Preliminary Acceptance (PA) Punchlist
EPC - DPW - Stormwater Section

Project Name:	Skyline at Lorson Ranch
EDARP Filing Number(s):	SF221
ESQCP Number:	ESQ229
Attendees:	DPW SW: Natasha Grimaldo, Ben Jones, Josh Augustenborg Stormwater Engineer: Mikayla Hartford and Glenn Reese (2/28/2023) Developer: Chris Ewen
Date of Walk-Thru:	2/21/2023
Walk-Thru Number:	1 st

FOREBAY DETAIL
NO SCALE

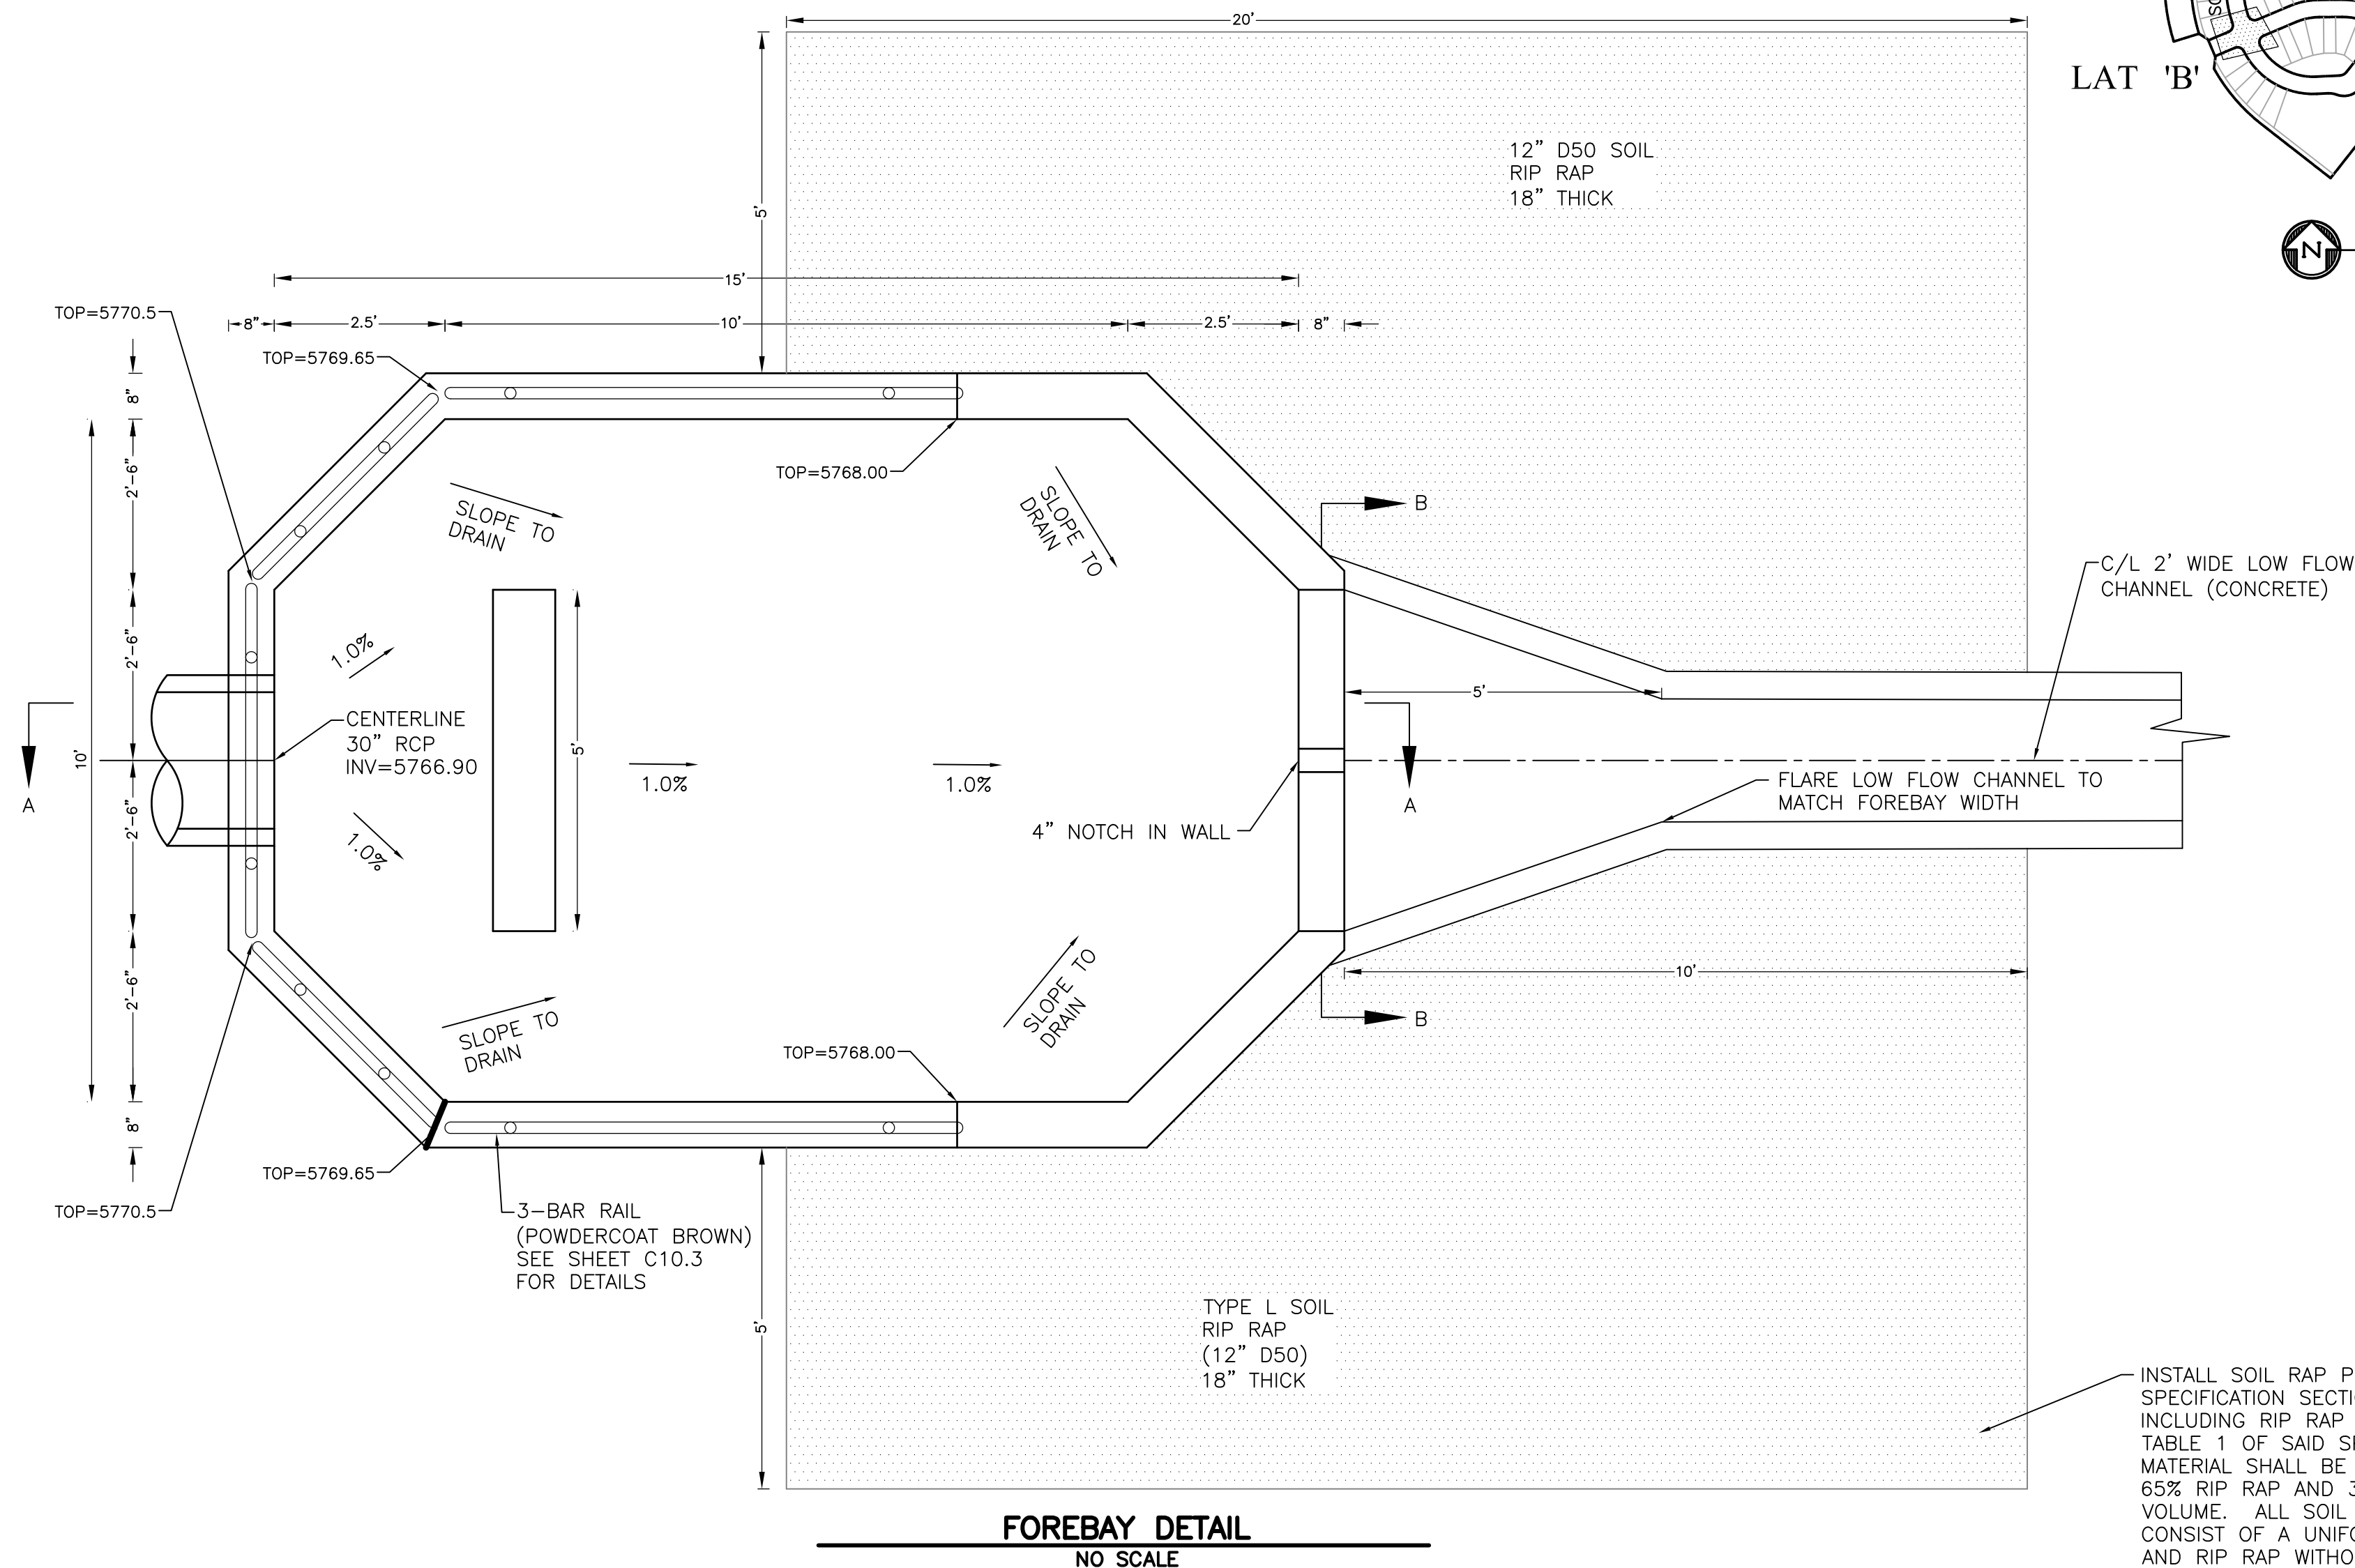
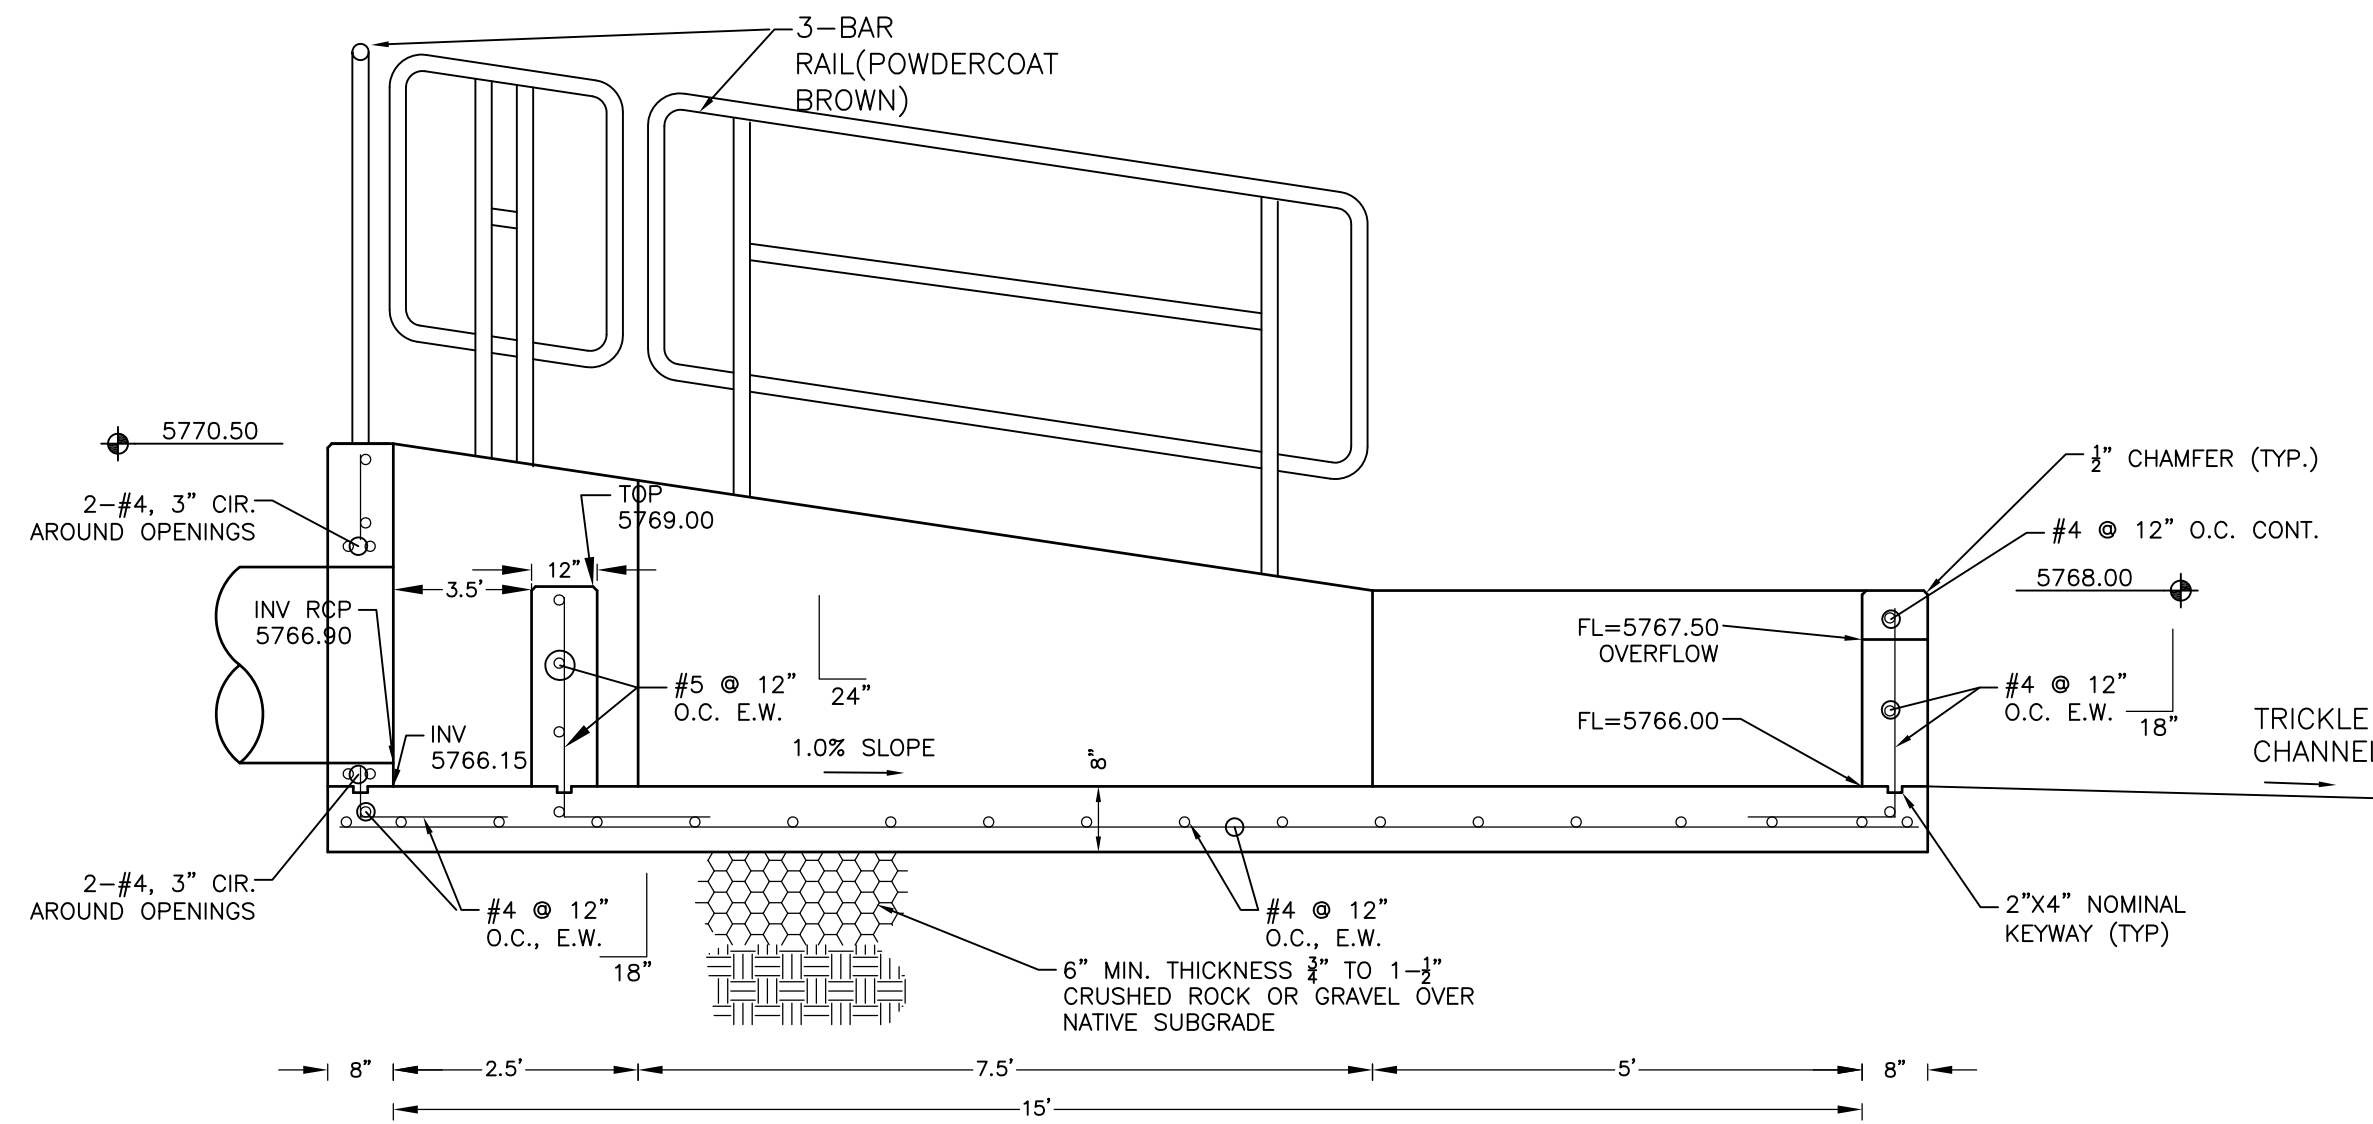
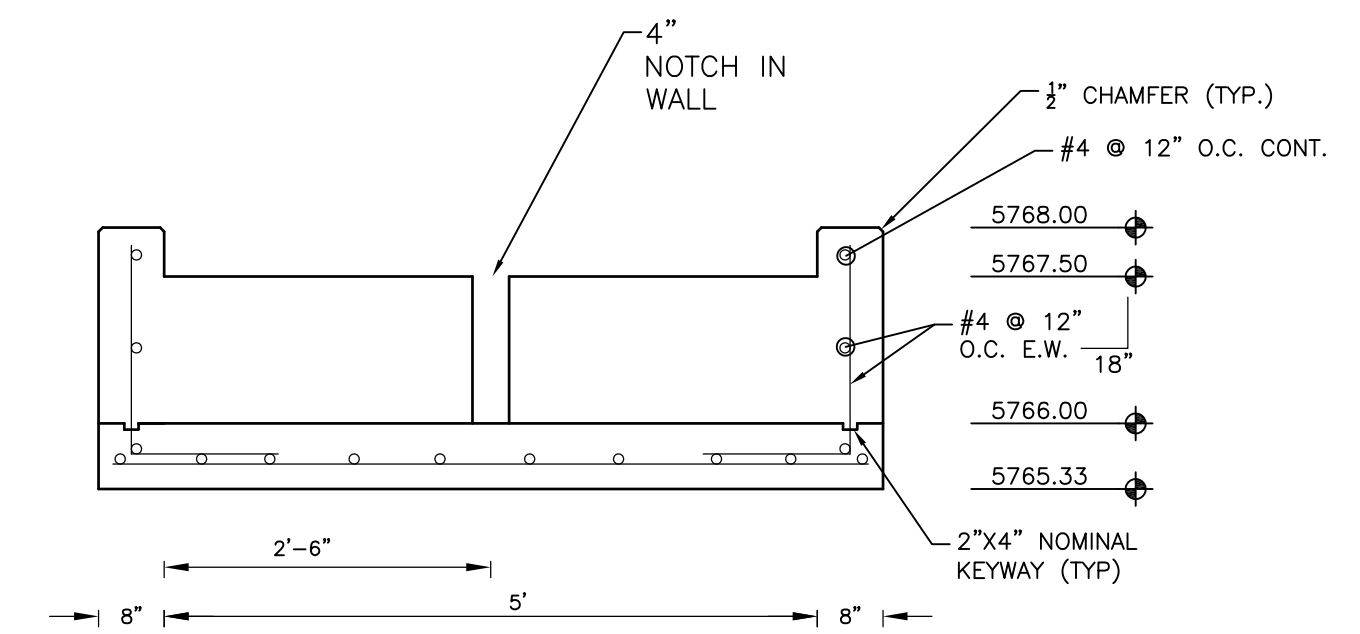
- Backfill behind trickle channel to bring the pond bottom to the top of trickle channel curb with a 3% slope towards trickle channel for positive drainage.
- Install missing handrail along forebay, per the forebay detail on sheet C7.2.
